Application for approval of details reserved by condition imposed under planning permission BN/7/18/PL relating to condition

Land to the north of The Flint Barn Yapton Road, Barnham

These details are provided as additional information following refusal to discharge the conditions with a previous submission BN/29/18/DOC

Drawing:
Drainage Strategy

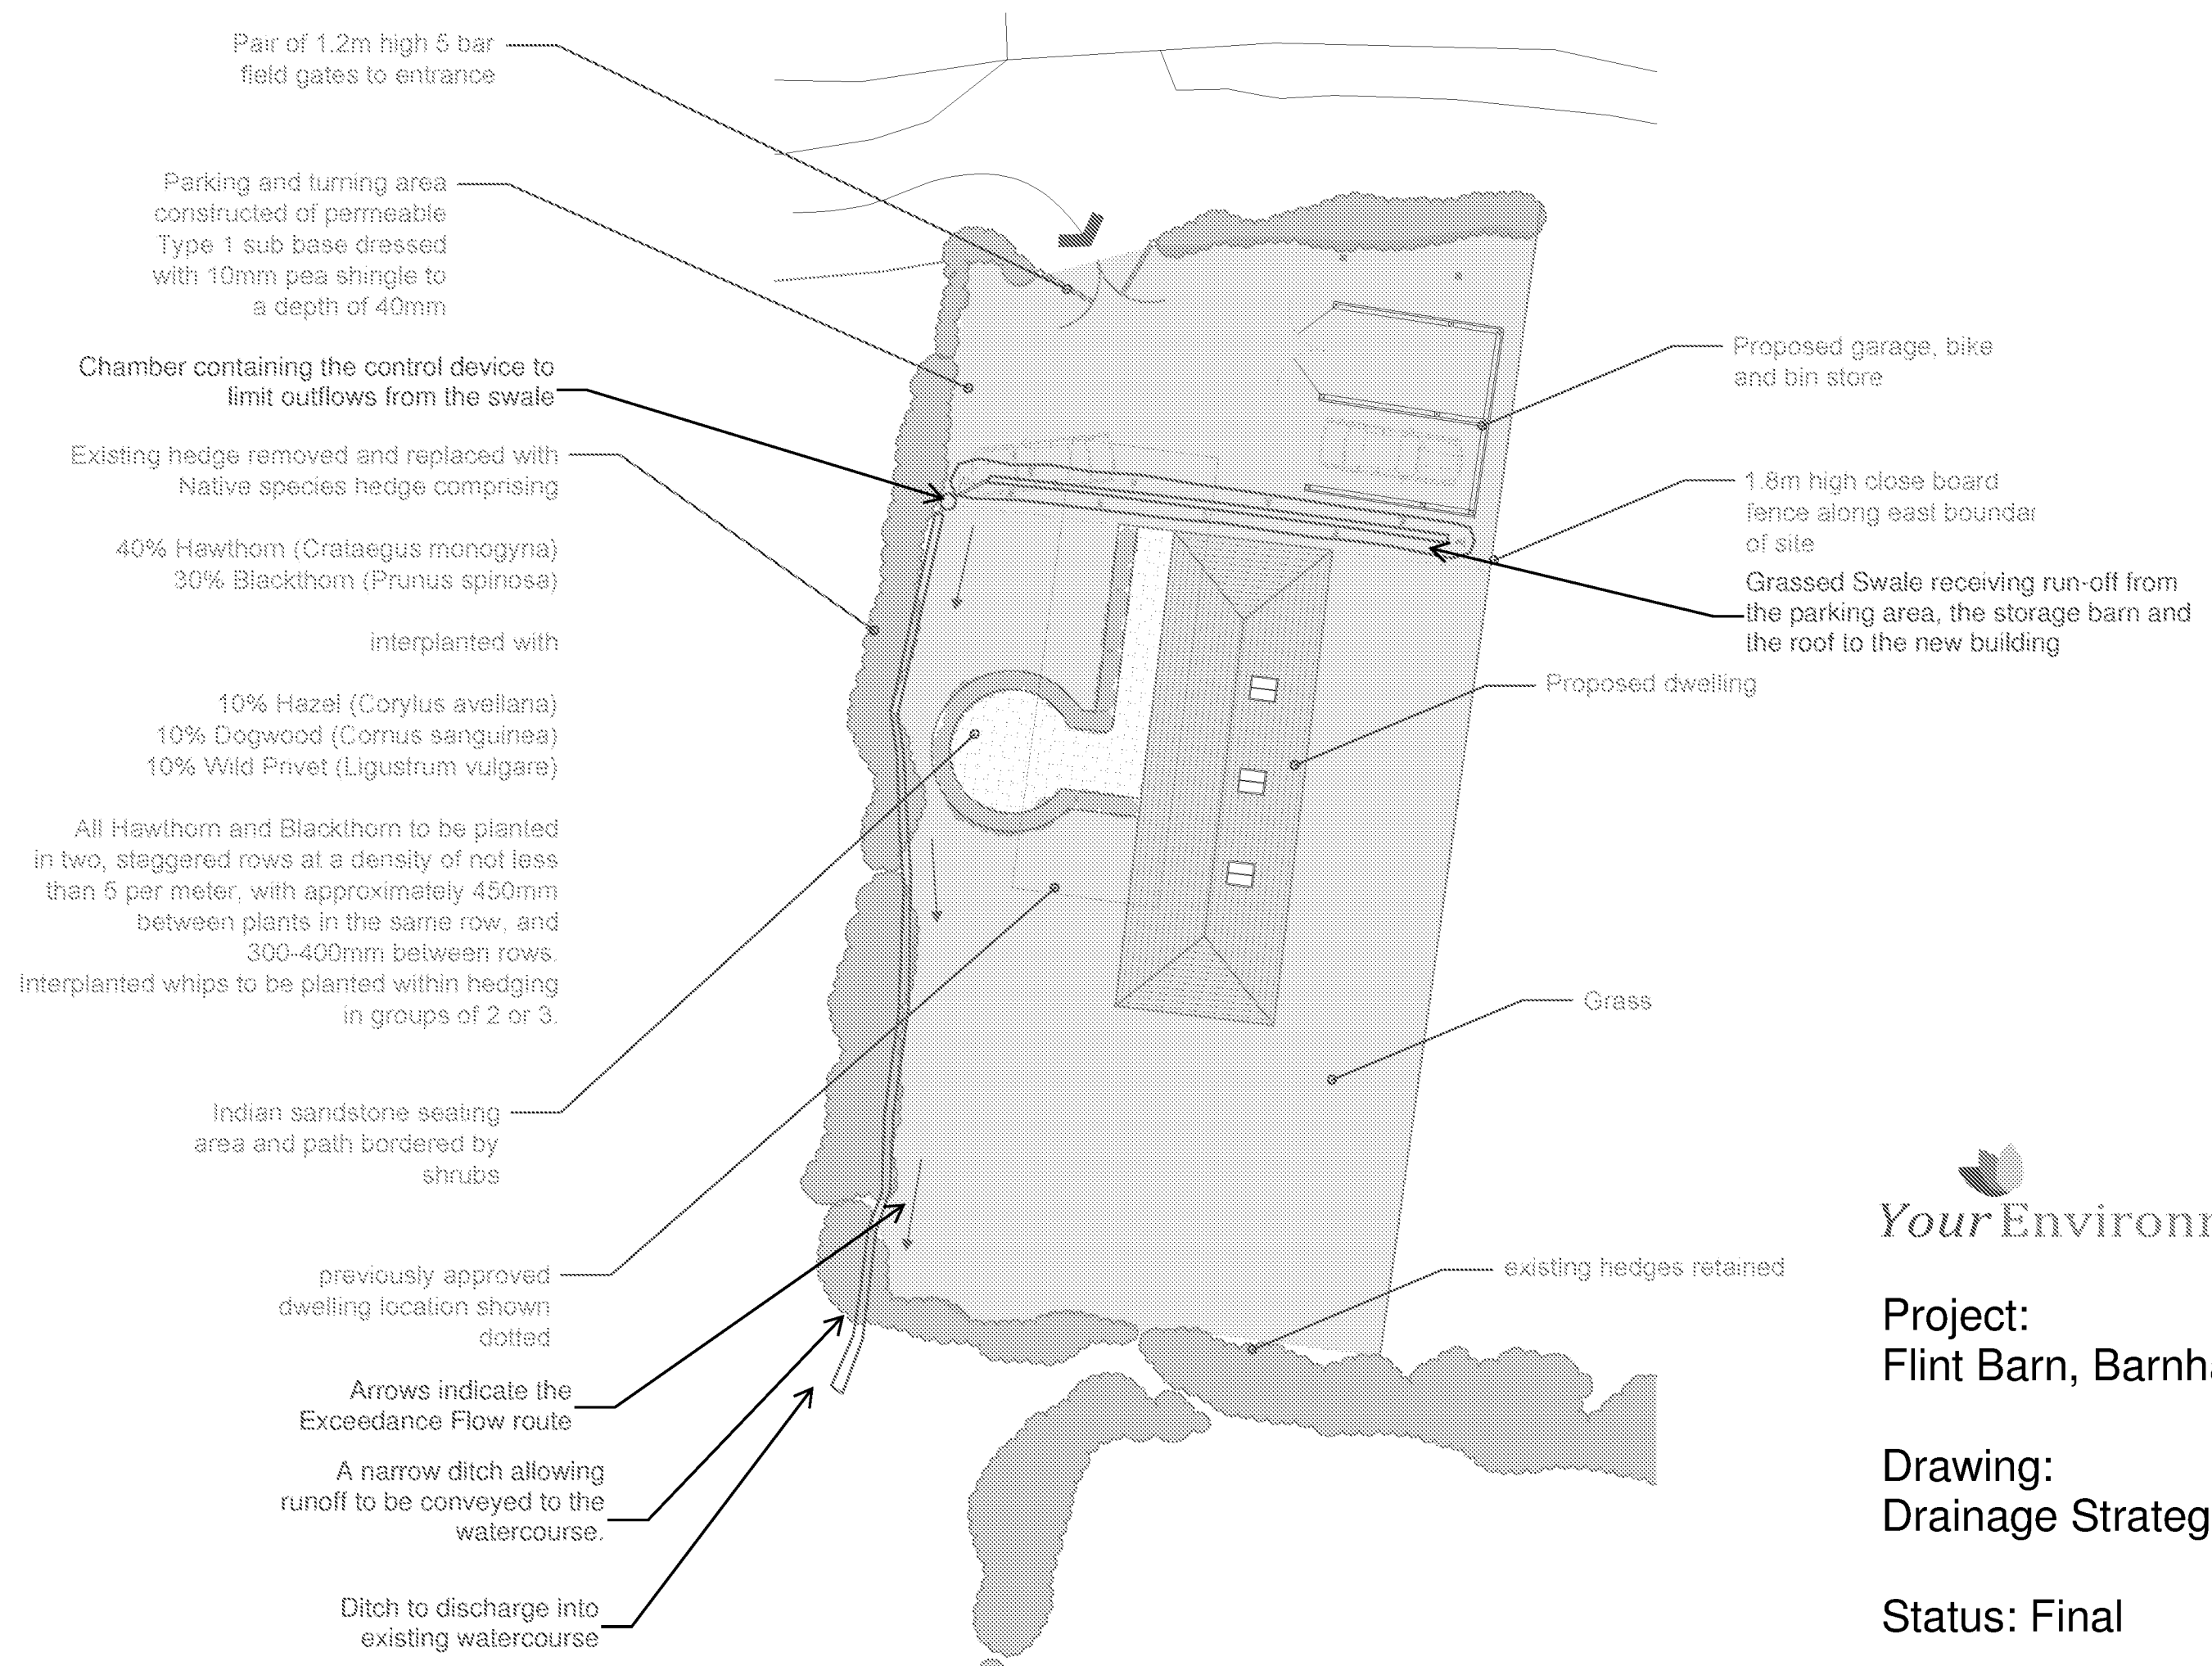
The applicant proposes to form a new swale and connect this into an existing ditch which runs to the south of the site. Winter groundwater monitoring was completed in March, which found ground water levels to be high. We believe groundwater would have peaked before March, therefore may be higher than those levels recorded and we agree with the conclusion that infiltration is unlikely to be viable. However, the applicant may wish to investigate shallow permeable paving solutions. The proposals currently include for the storage of the 1 in 30 year rainfall event on site. Please revise the plans to accommodate the 1 in 100 year plus 40% climate change event on site. Please also clarify the rate of discharge proposed, orifice diameters have only been provided. In order to discharge flows to an ordinary watercourse the applicant will need to obtain Ordinary Watercourse Land Drainage Consent, (the consent forms will be forwarded separately). I have inspected the watercourse which the applicant proposes on discharging into, it is heavily overgrown. The condition of this watercourse will need to be improved to ensure that flow can be conveyed downstream. The watercourse is culverted and runs under Yapton Road, the condition of this may also need to be reviewed.

Following discussion with Laura Gibbons it was agreed that a reasonable maximum discharge rate from the site to replicate pre-development conditions is 2 litres per second.

This maximum discharge rate has been applied to the 1 in 100 year + 40%cc allowance storm event.

It requires a protected orifice plate of 47mm diameter to be located at the discharge point from the site. The form and alignment of the swale does not change from that proposed previously.

Under these conditions, the hydraulic modelling (attached) shows that 1.5m³ of flooding occurs. This flood volume will spill from the swale and follow the surface profile to the south. It will drain into the landscaped seating area where it will pond and be allowed to percolate naturally into the ground after the storm has passed.

During the 1 in 30 year return period storm event, the discharge rate is limited to 1.8l/s. No flooding occurs.
